City of Albuquerque Stormwater Construction Site Inspection Report

ESC File No.	K10E070	Project Name:	Irby BTS		
NPDES Id. No.	NMRT00603	Location:	7226 Central Ave SW		
5/5/2025	Owner	Contractor			
Operator	Skyview West Industrial Park , LLC	Brunacini Development LTD. Co.			
Contact name & title	George Brunacini	Javier Vargas, SI			
e-mail	gbrunacini@brunacini.com	jvargas@brunacini.com			
Contact Phone #	505-833-2928				
COA Inspector	James Hughes	Start	11AM		
Construction Phase:					
Type of Inspection:	Regular	Storm Event	Post Storm Event >0.25"	311/Complaint	
Weather at time of inspection?		Temperature: ~ 50			
Estimated date of last storm 0.25" or greater		5/4/2025

ENGINEER'S SEAL	SKYVIEW WEST ALBUQUERQUE, NM	DRAWN BY pm	
 10-21-24		DATE 10-21-24	
		GRADING PLAN	DRAWING
		 <i>TIERRA WEST, LLC</i> 5571 MIDWAY PARK PL NE ALBUQUERQUE, NEW MEXICO 87109 (505) 858-3100 www.tierrawestllc.com	SHEET # GR-1
			JOB # 2023062
RONALD R. BOHANNAN P.E. #7868

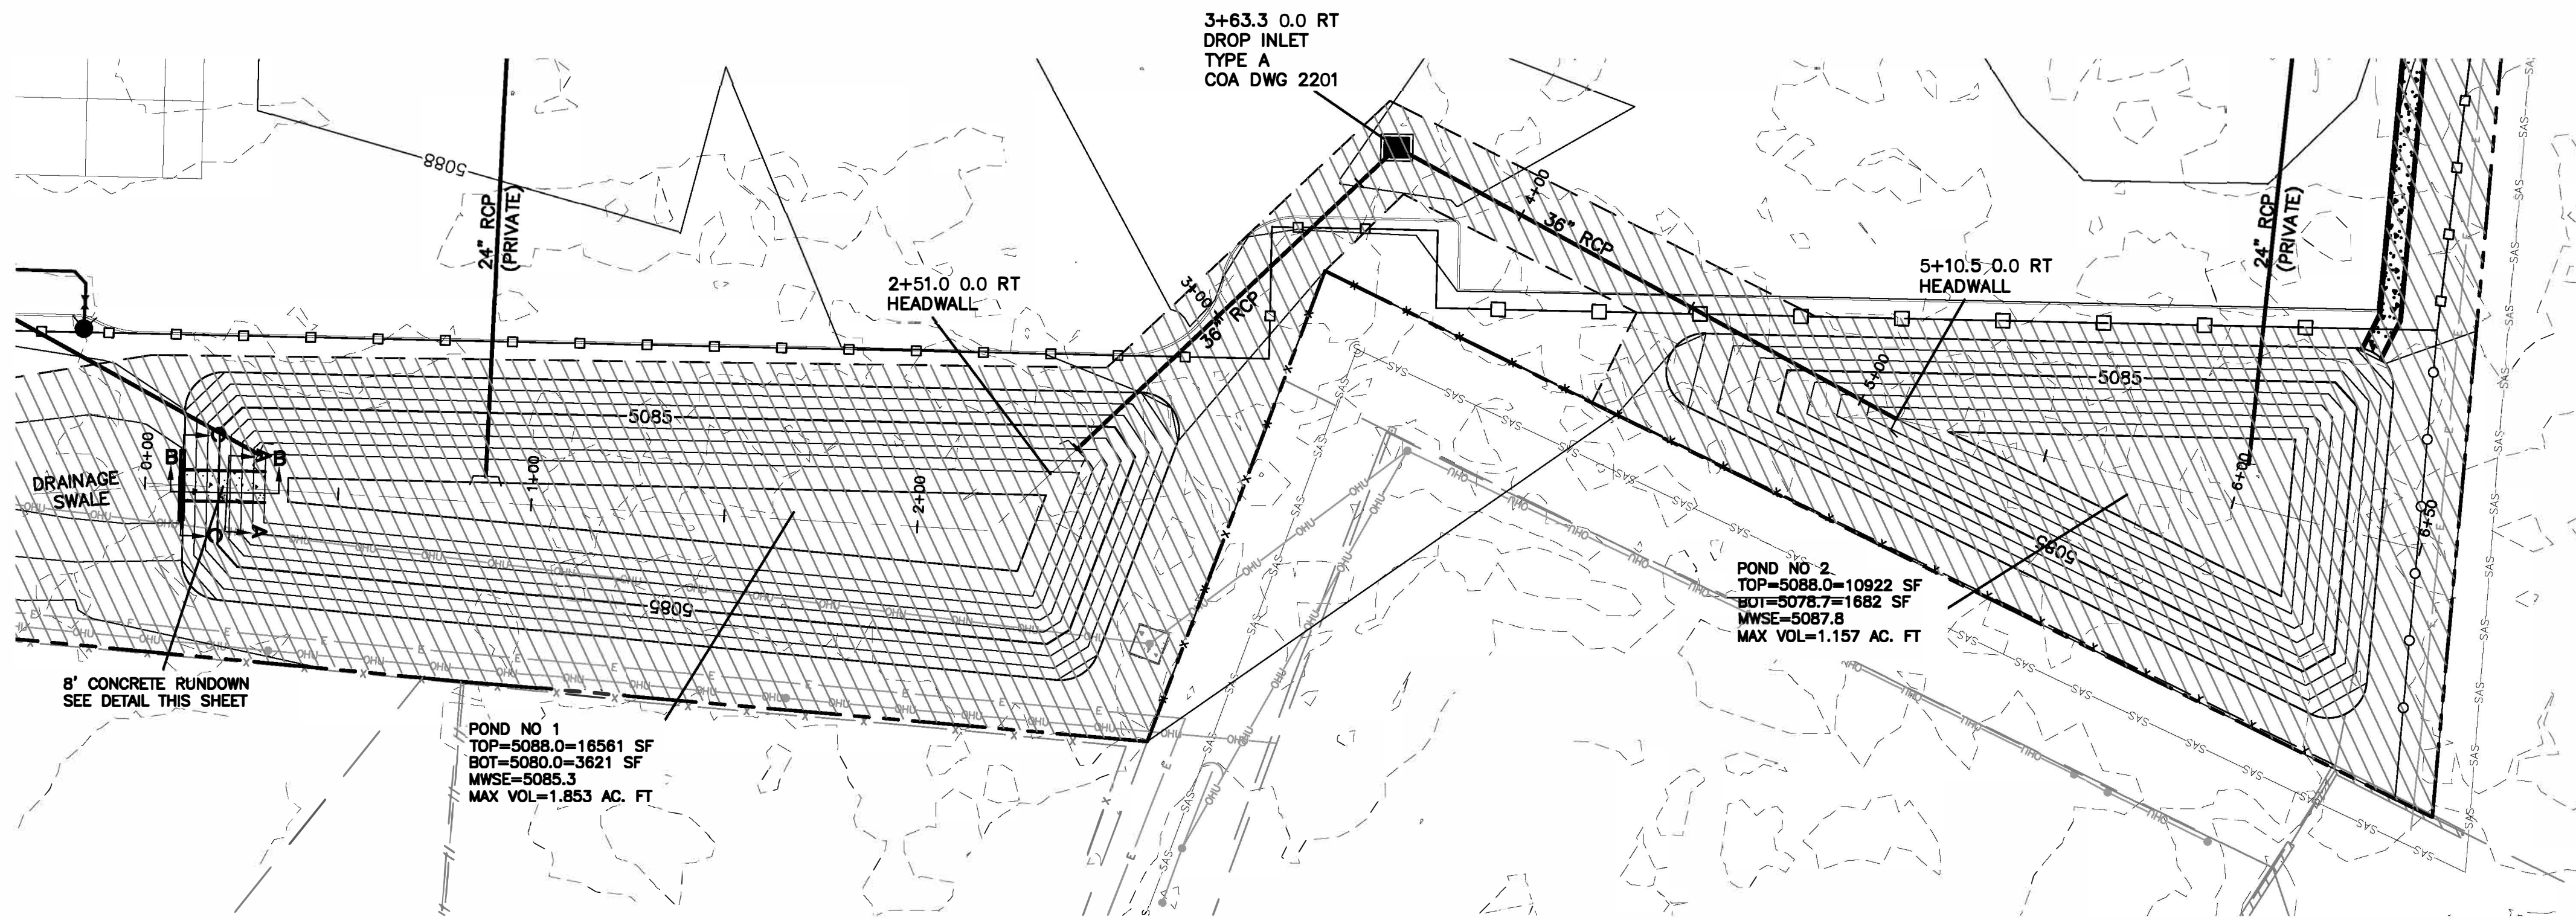
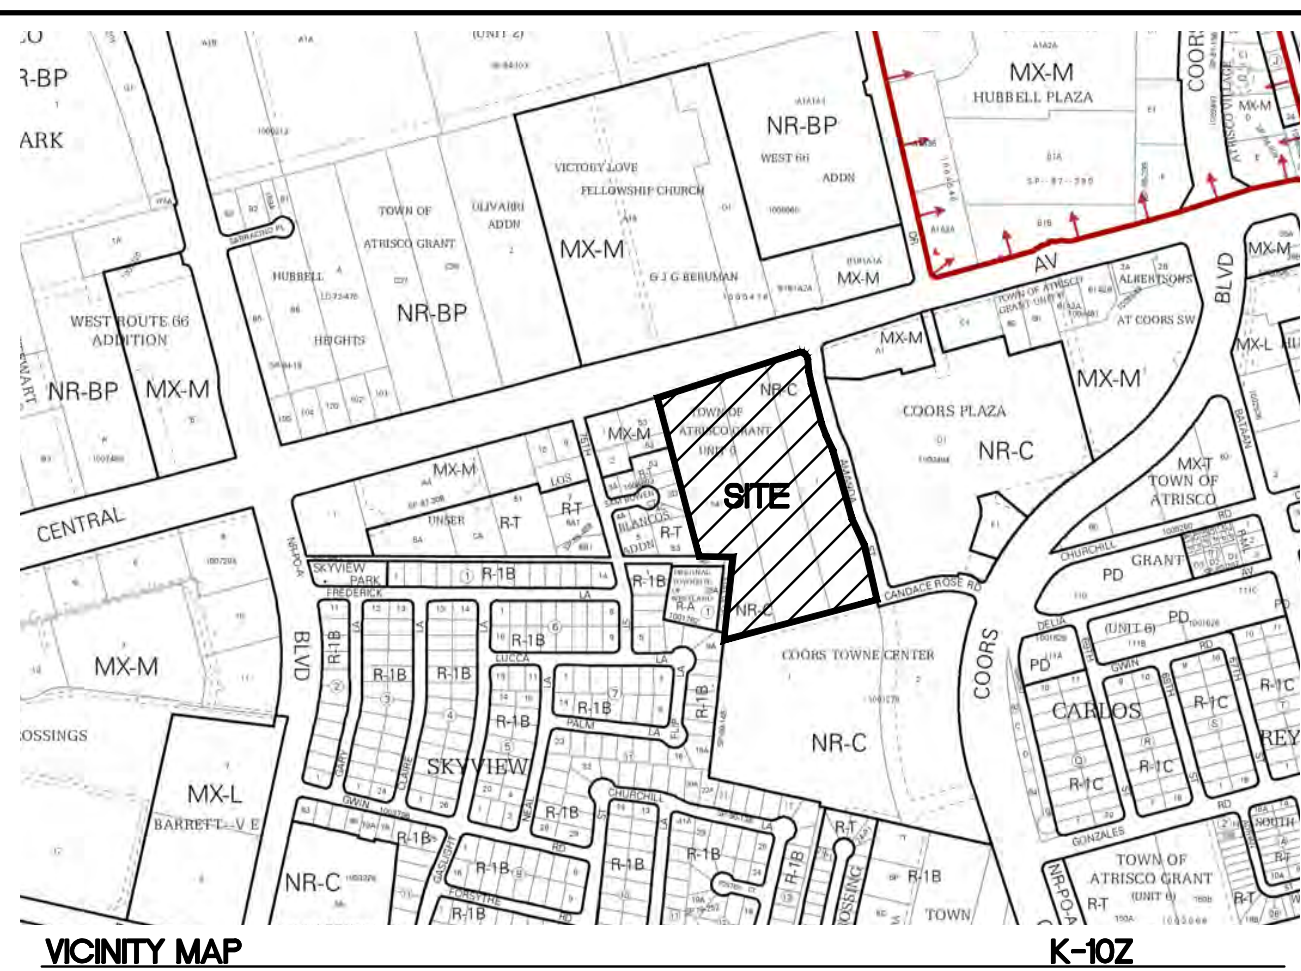
Item Number	Deficiency/ Corrective Action				
5	Sediment had been deposited into Amanda St., east of the site, and not removed within 24 hours in violation of CGP 2.2.4.d. Required mitigation: Remove sediment deposited in the streets by the end of the same business day. Remove the sediment by sweeping, shoveling, or vacuuming these surfaces or using other similarly effective means of sediment removal. You are prohibited from hosing or sweeping sediment per CGP 2.2.4.d.
